MEMORANDUM

TO: Nell Donaldson, Planner
FROM: David Senus, P.E.
DATE: November 12, 2014
RE: Pamela Road Extension, Final Level II Site Plan Application

Woodard & Curran has reviewed the response to comments for the Final Level II Site Plan Application for the proposed extension of Pamela Road in Portland, Maine. The project involves the construction of approximately 750 feet of new road along a paper right-of-way that was established in 1969.

Drawing Name:
GRADING & DRAINAGE PLAN

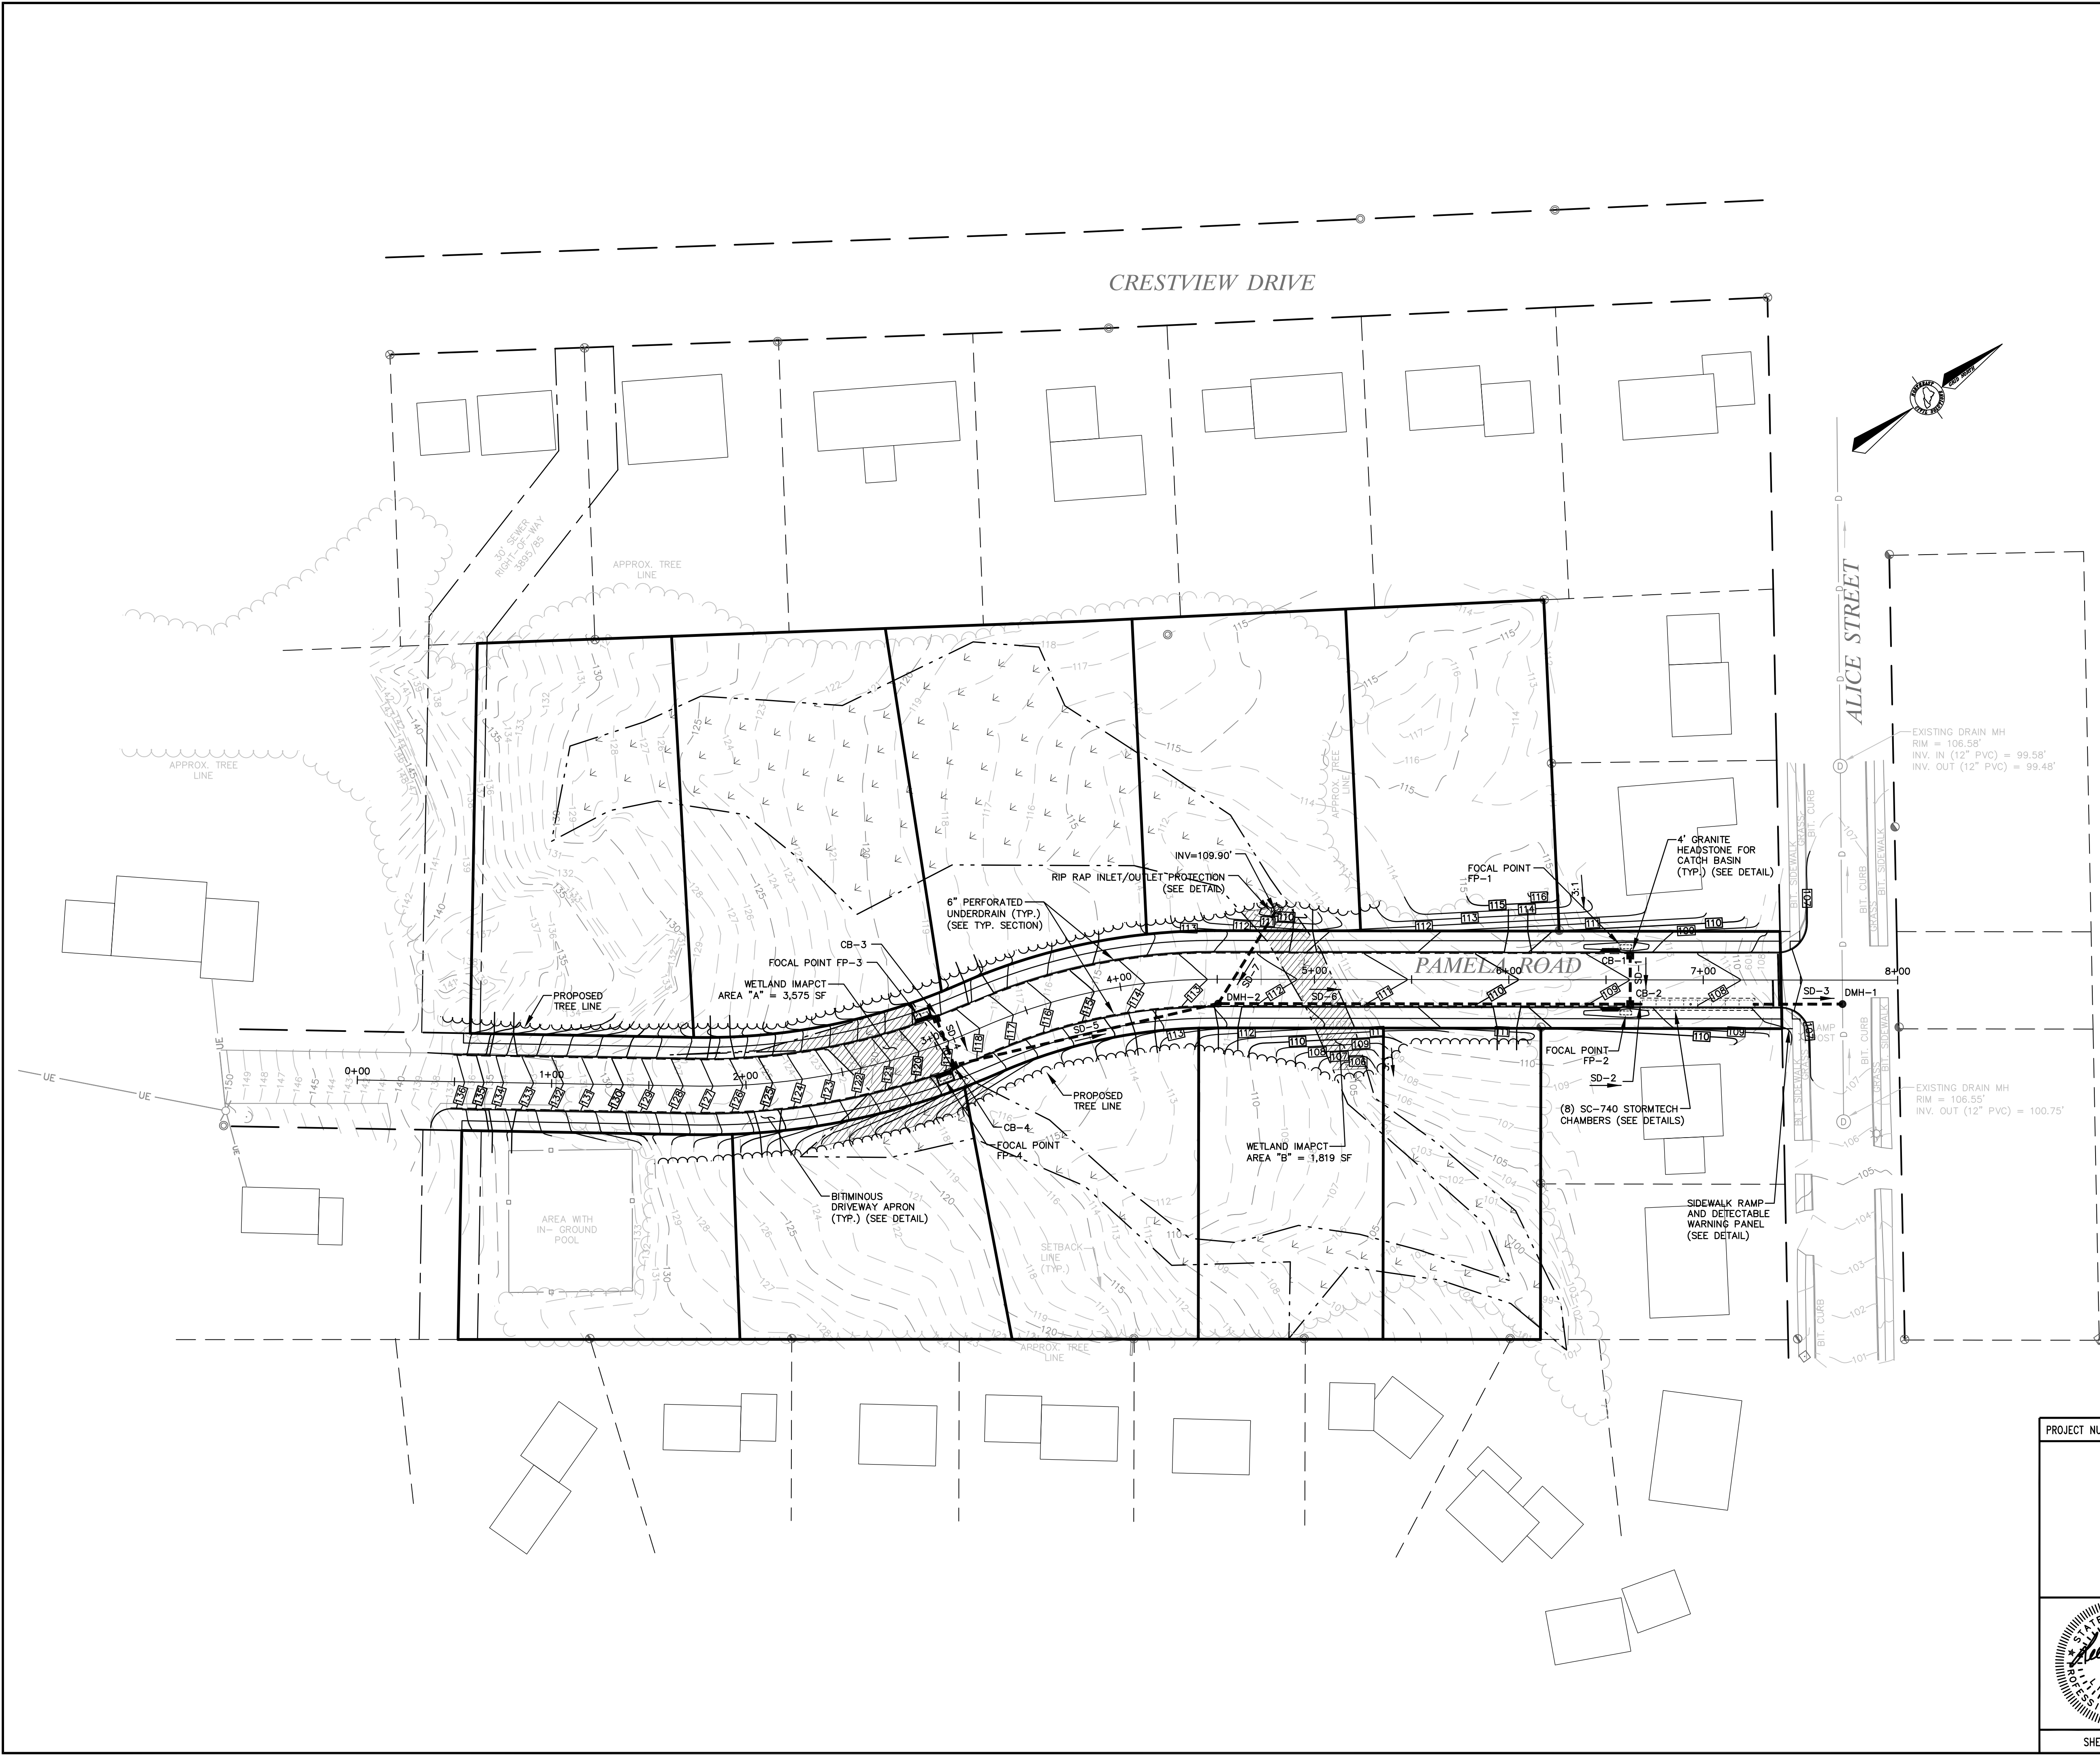
- 1) The Applicant awaits letters from utilities confirming acceptance of the design, and has noted that they will be forwarded to the City Planning Office as soon as they are received.
- 2) Pipe inlet protection should be identified for the inlet of pipe SD-7.
- 3) All previous review comments have been adequately addressed.
